**From:** Bloomer, David <David.Bloomer@lancashire.gov.uk>  
**Sent:** 08 February 2019 13:50  
**To:** Stephen Kilmartin  
**Cc:** LHS Customer Service; planning  
**Subject:** app3/2019/0081 Land off Waddington Road

The proposal is for a discharge of conditions relating to planning approval 14/0597

WADDOW VIEW, CLITHEROE  
EXECUTION PLAN

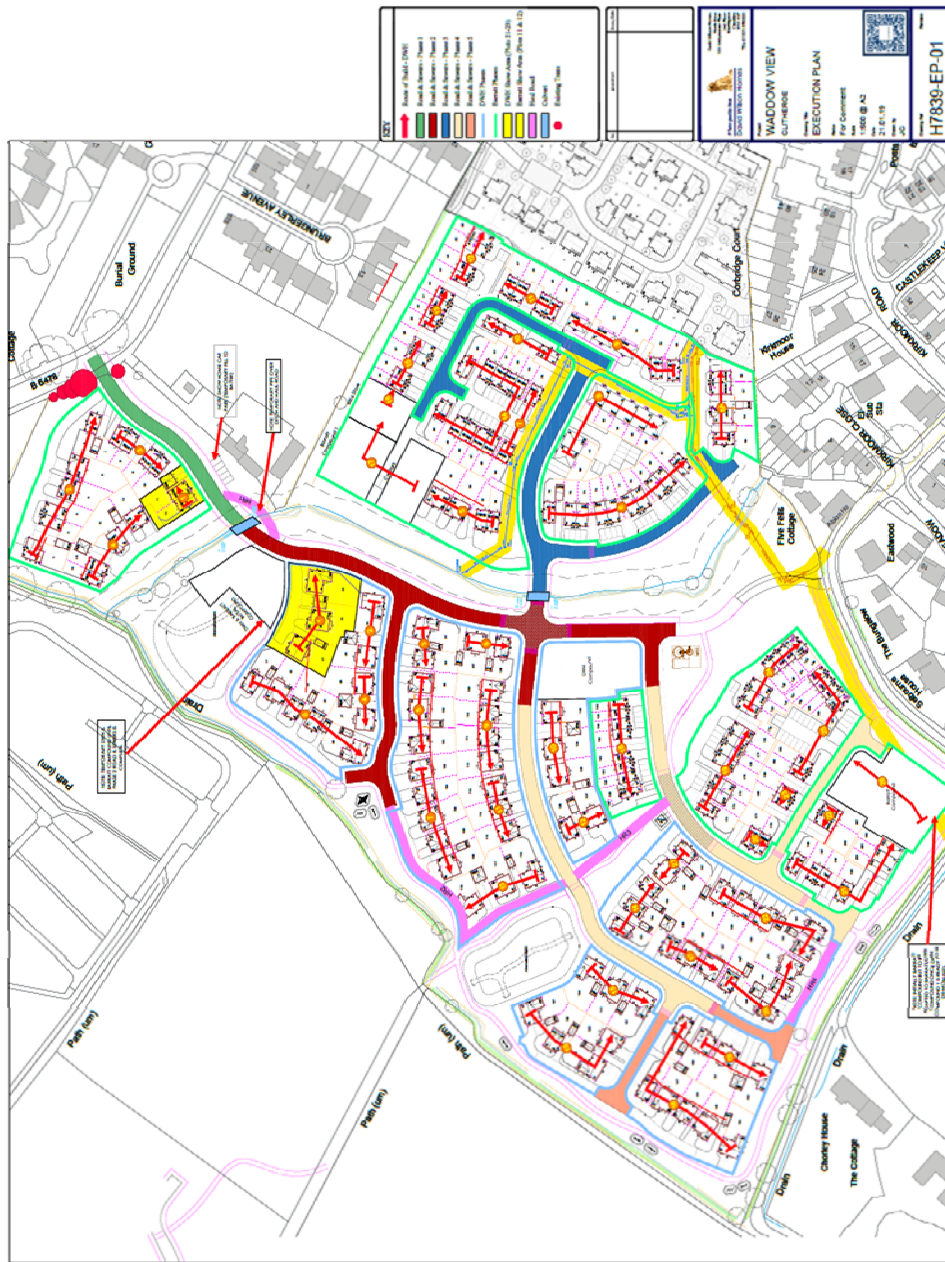
Condition 7 Construction method statement. This is partially dealt with in the Construction Environmental Management Plan however there are a number of areas that need further attention. The site compound plan is proving illegible, I have failed to identify the wheel washing areas. In the CEMP the transport section (pg15) refers to a Traffic Management Plan being created. I am unable to locate this document.
